Response to Validation Questions

Existing Elevations
1:200 @ A3

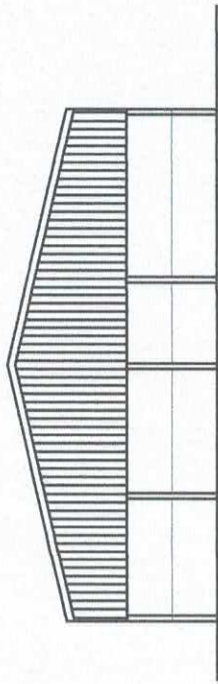
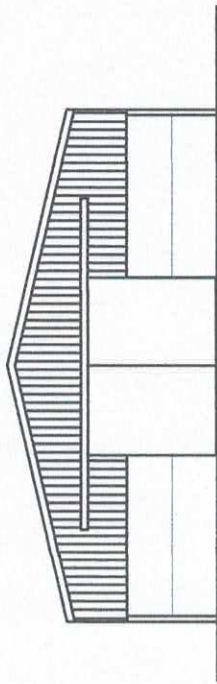
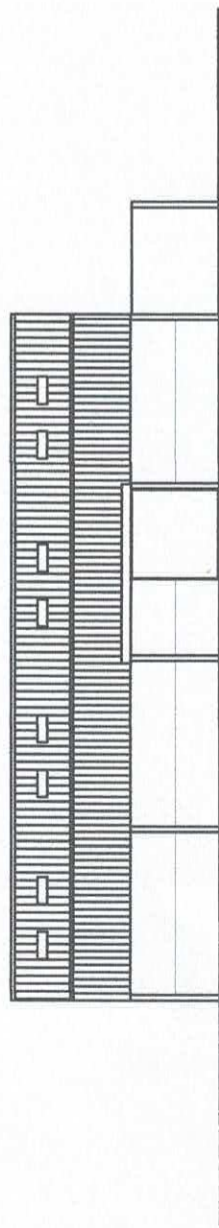
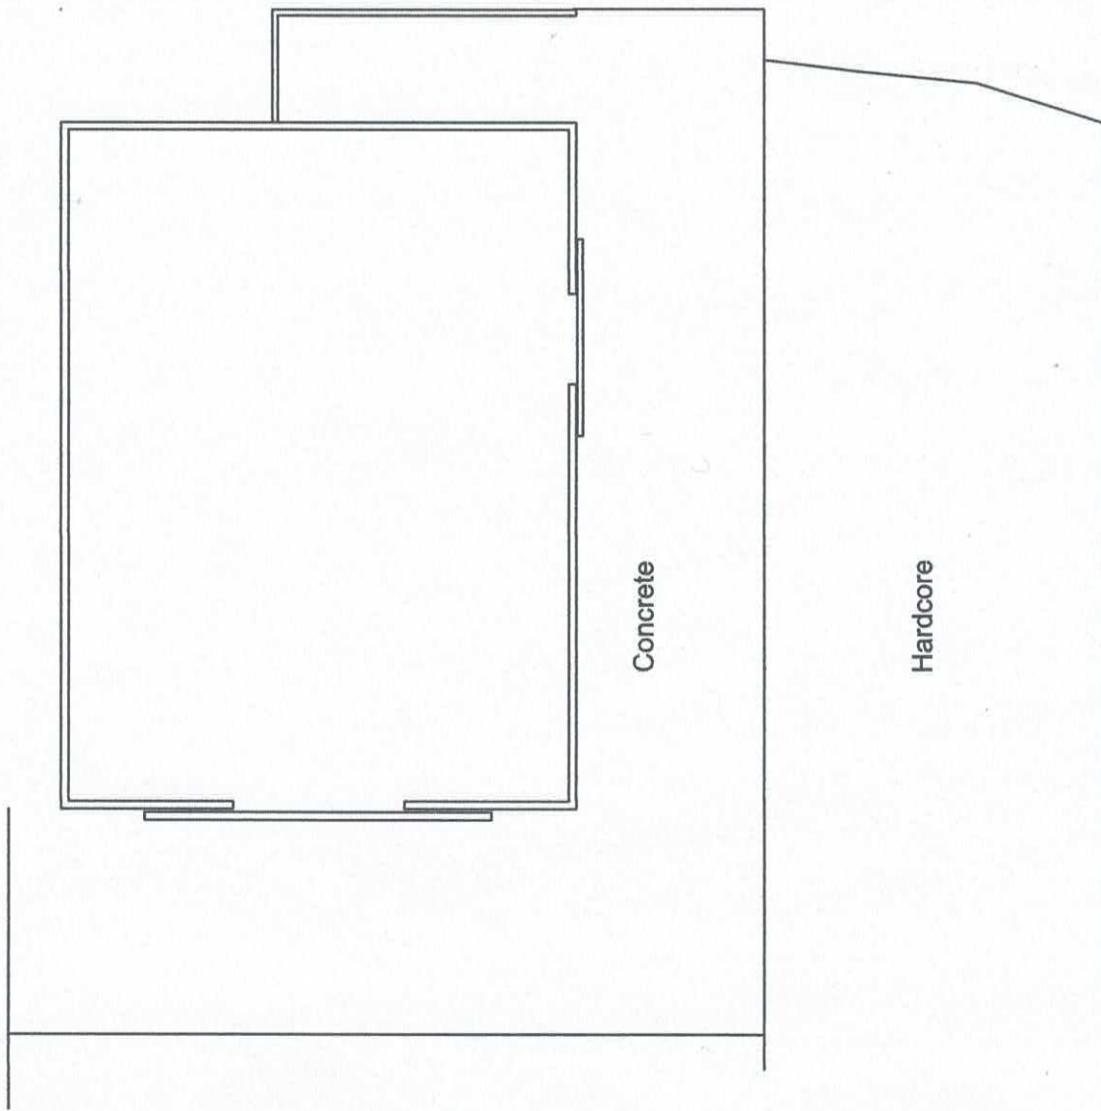
- **Existing elevations / floor plan drawing doesn’t include what appears to be an additional existing building to the South of the existing building shown – this building needs to be shown on the existing elevations / floor plan drawing if it is still on site**

No permanent building ever located on this site (see above)
